## Portishead Branch Line (MetroWest Phase 1)

8.6 – Letter from Colin Medus, North Somerset Council re: Offsite planting on the A369 Portbury Hundred dated 12 September 2019

**The Proposed Portishead Branch Line (MetroWest Phase 1) Order  
Offsite planting on the A369 Portbury Hundred**

Approved by: CW Date: 18/07/2019

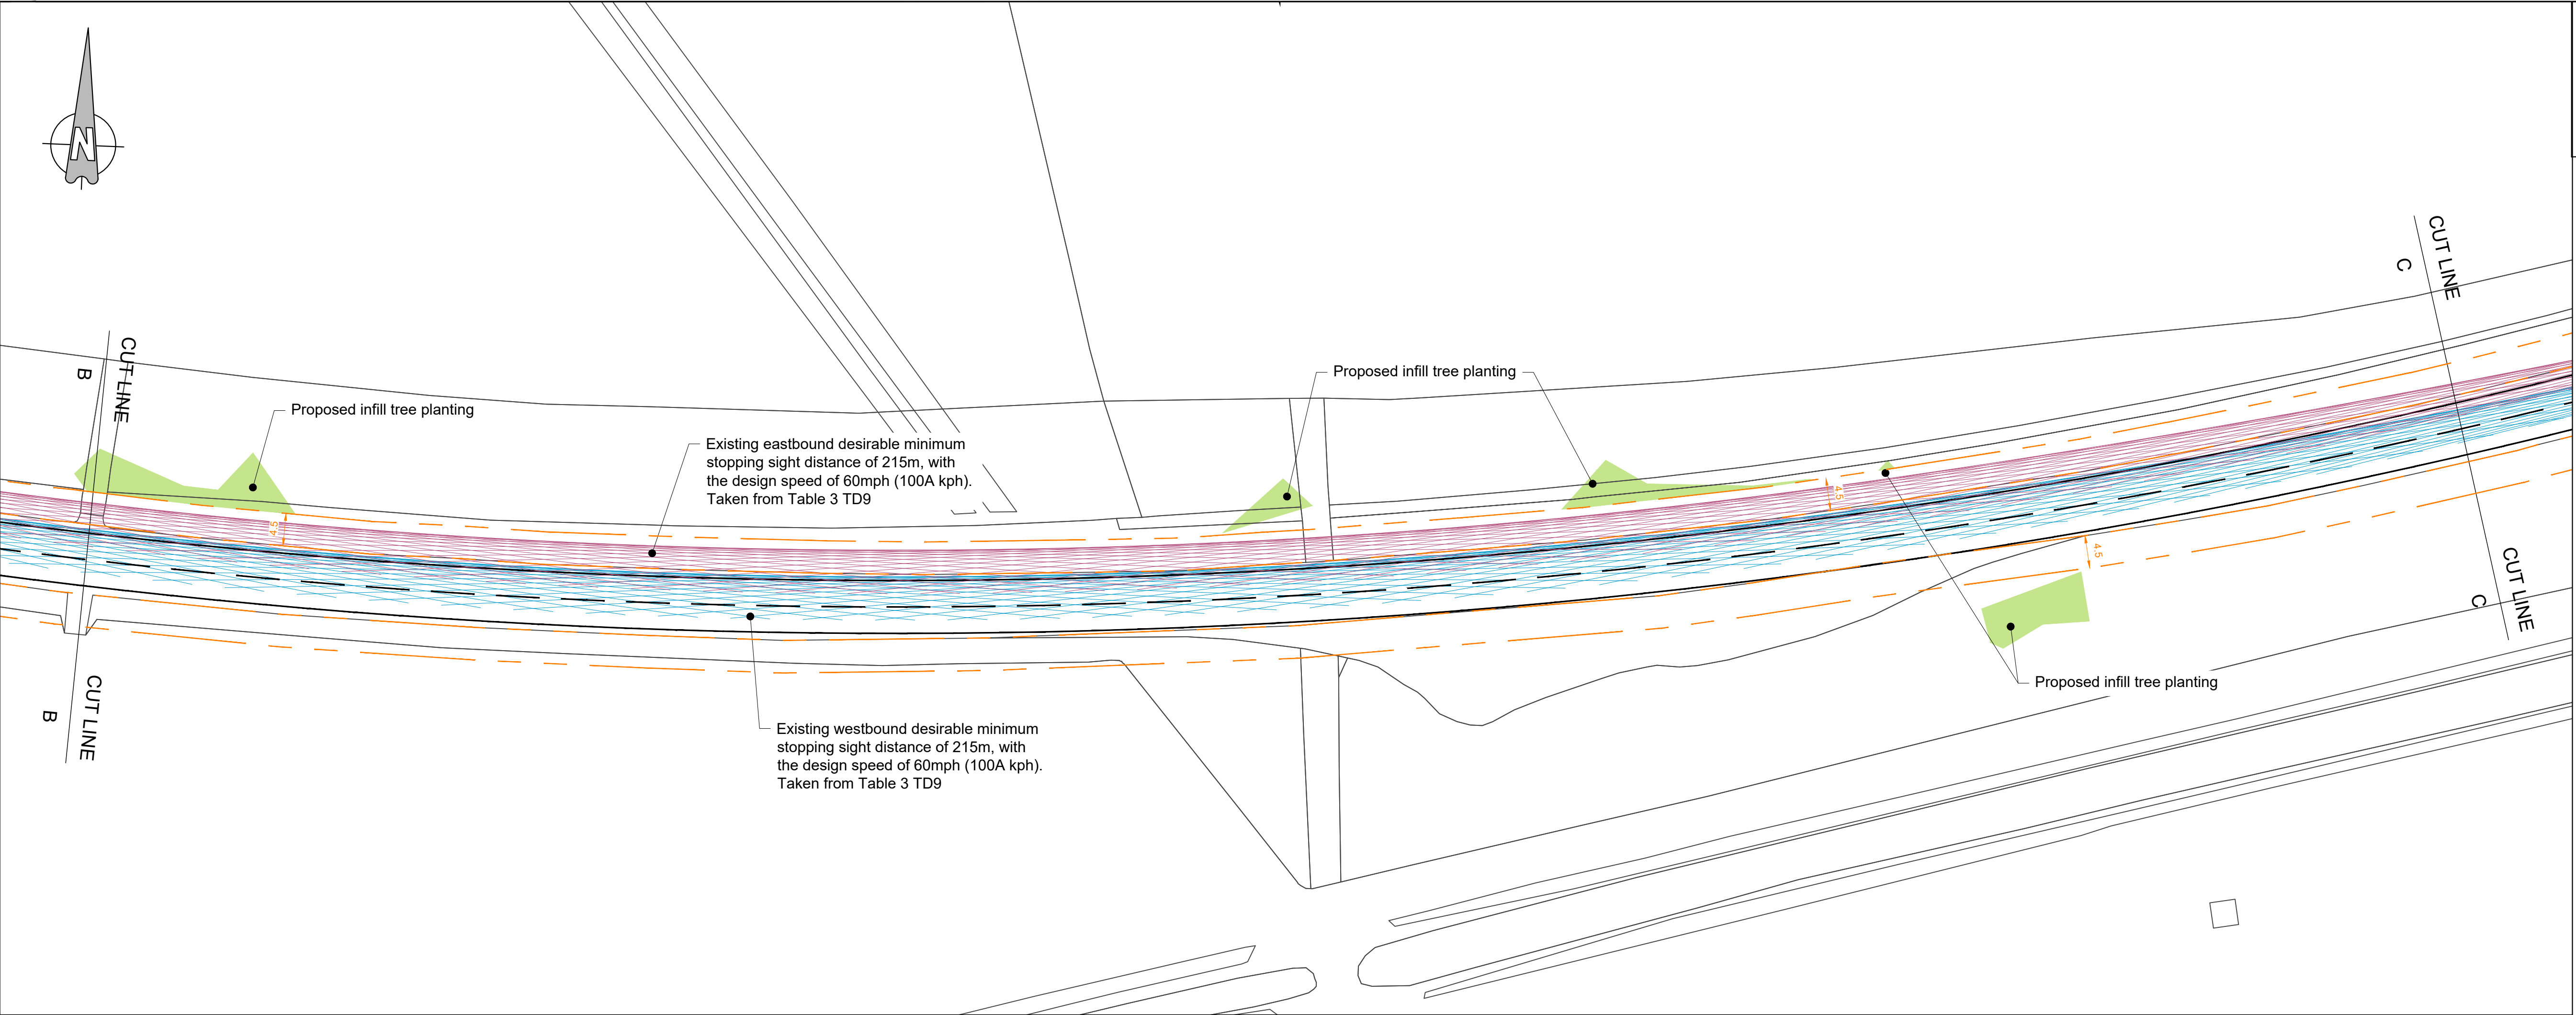
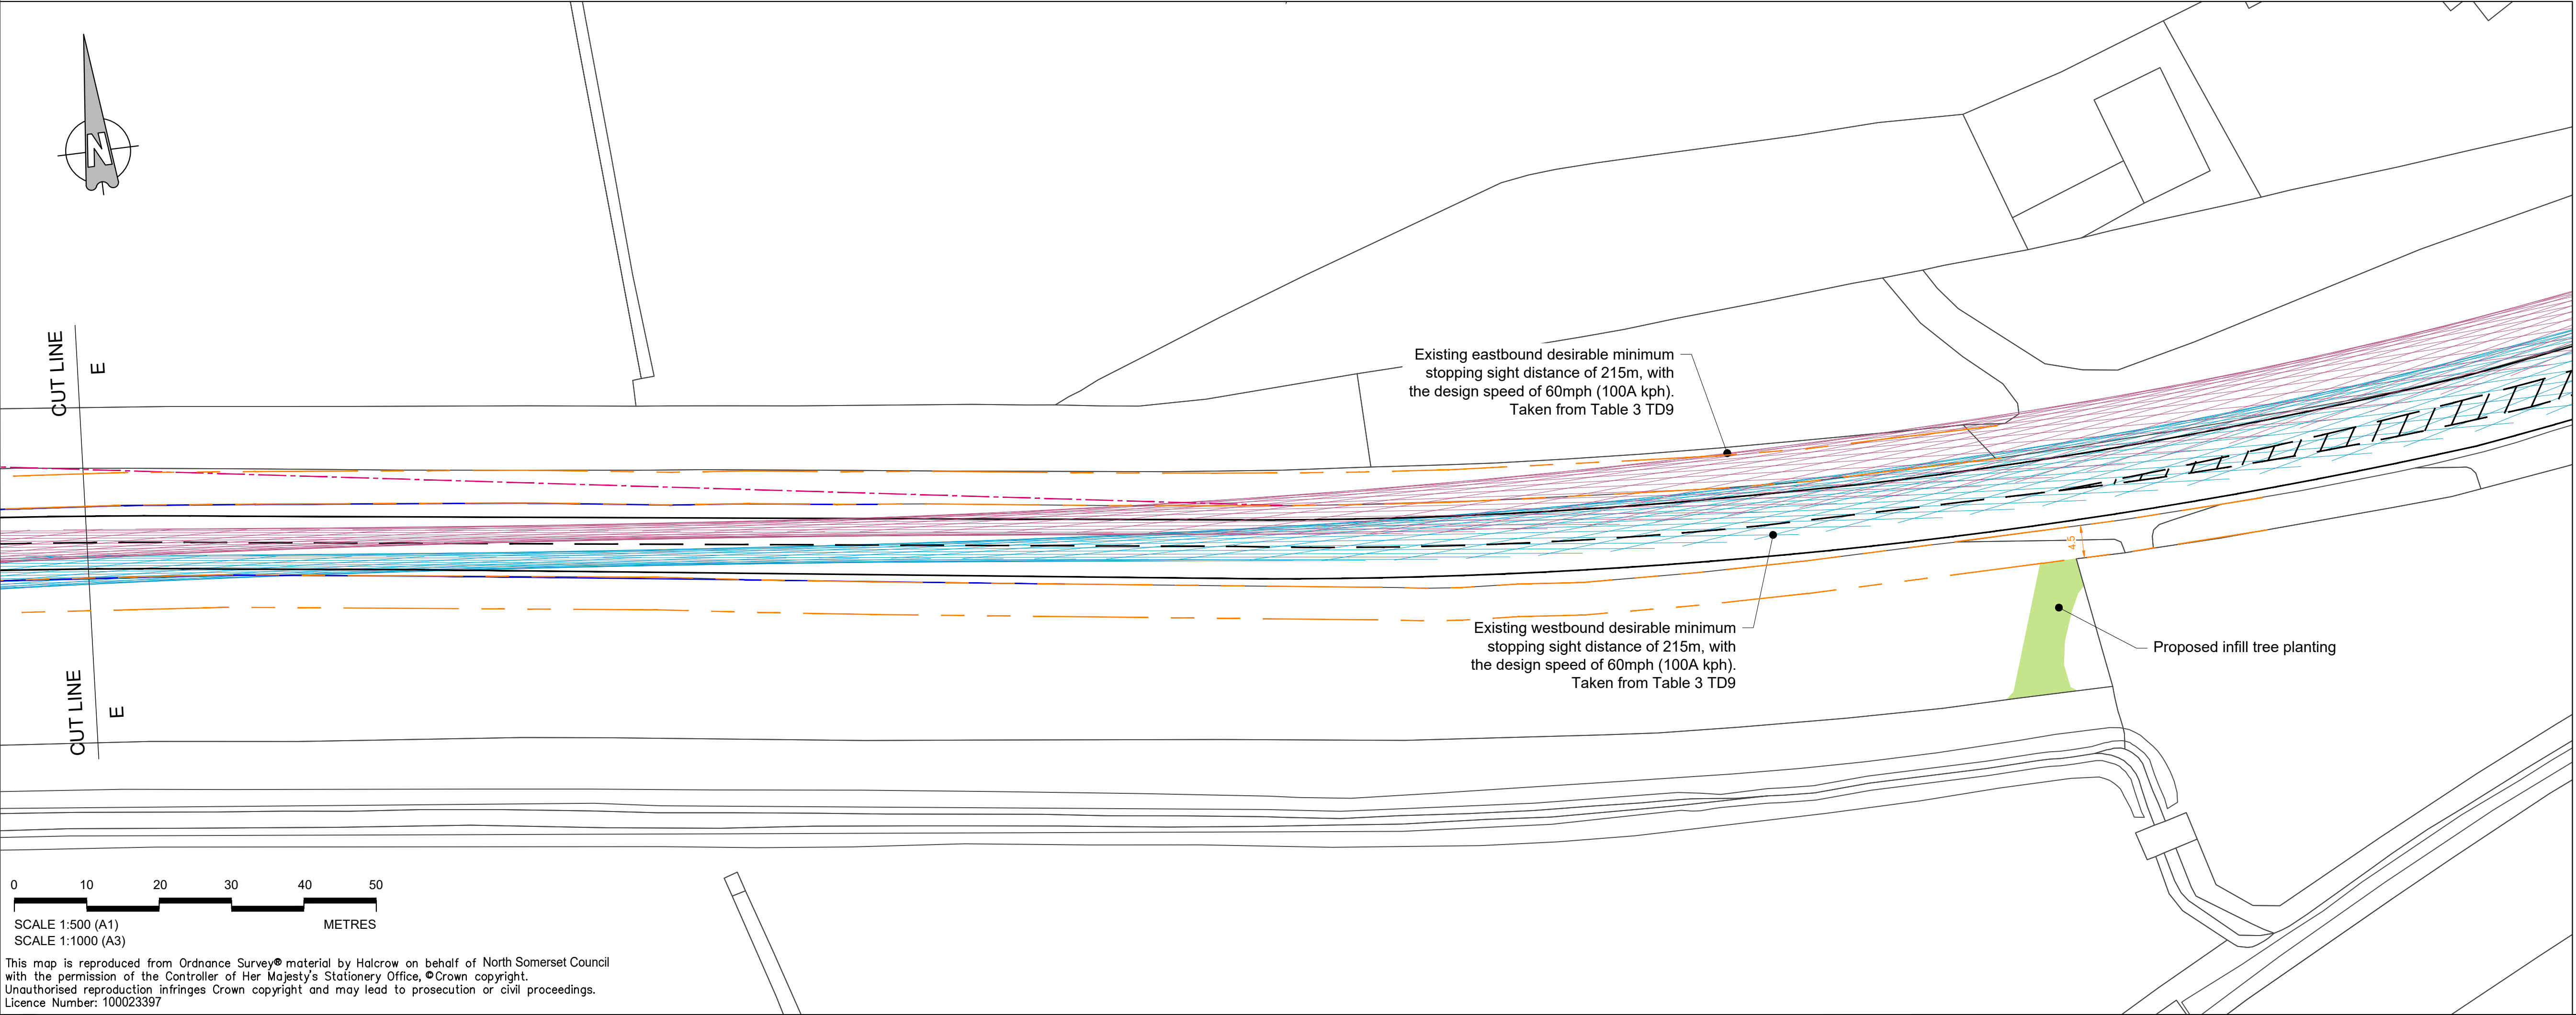
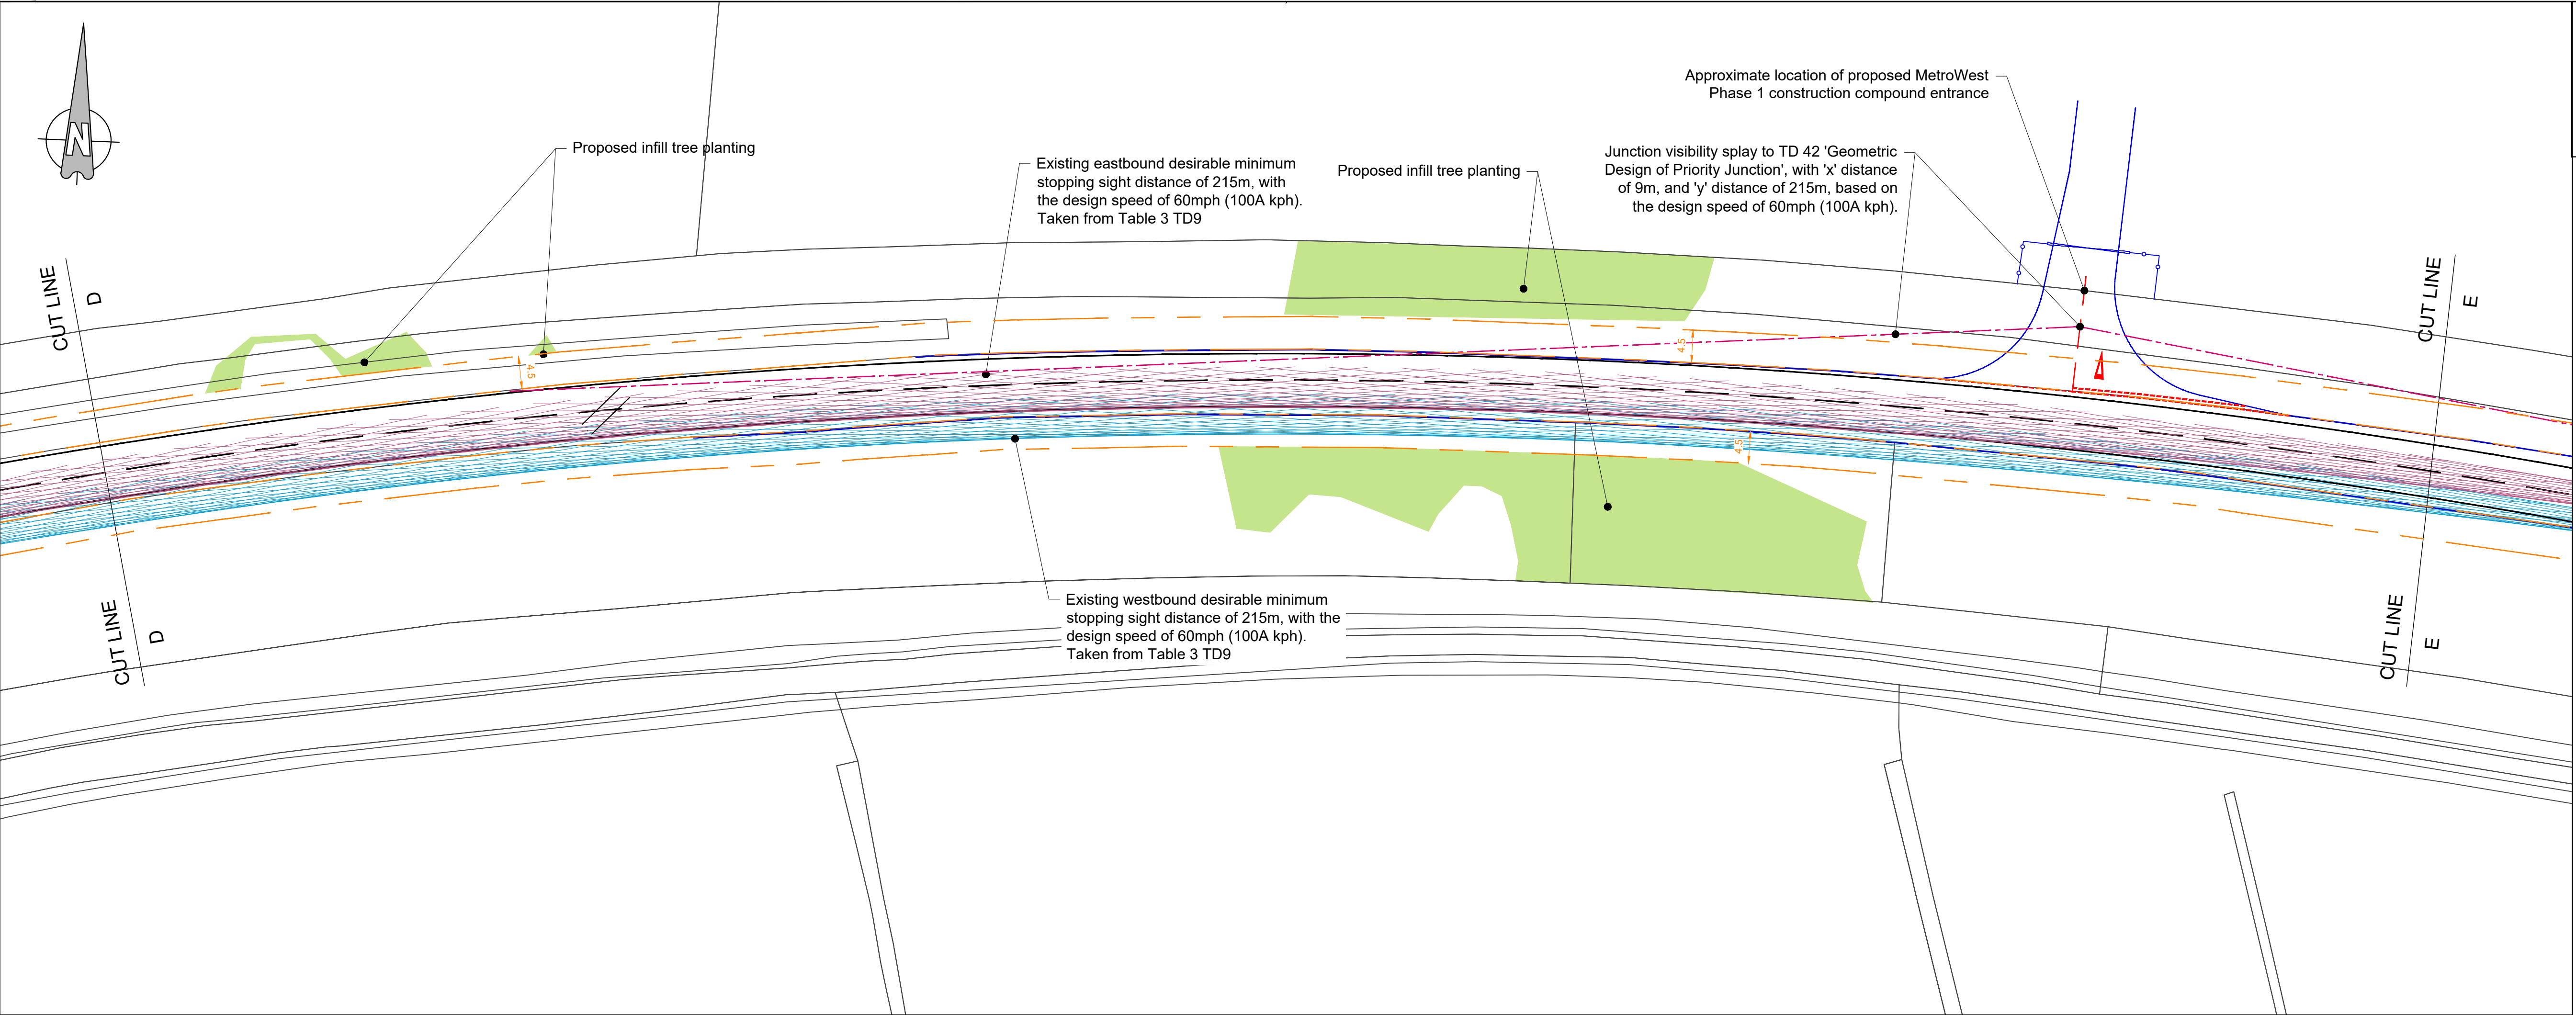
I understand this proposed planting (which is shown on plans 467470.BQ.04.20-610 to 613 enclosed with this letter) is required to provide an alternative bat commuting corridor in addition to that currently provided by the disused railway.

I can confirm that all of the proposed planting shown on the plans referred to above is within the public highway and the sum of tree planting totals 0.52 hectares. The following tree species would not be acceptable; willow and poplar. The types of tree species we would accept are field maple, hawthorn and hornbeam. A tree planting list can be agreed at the detailed design stage.

I can also confirm that North Somerset Council as local highway authority is content to, at the relevant time, grant licence to the MetroWest project and its contractors to provide the proposed planting in accordance with the plans referred to above, subject to agreement at the detailed design stage on the planting list.
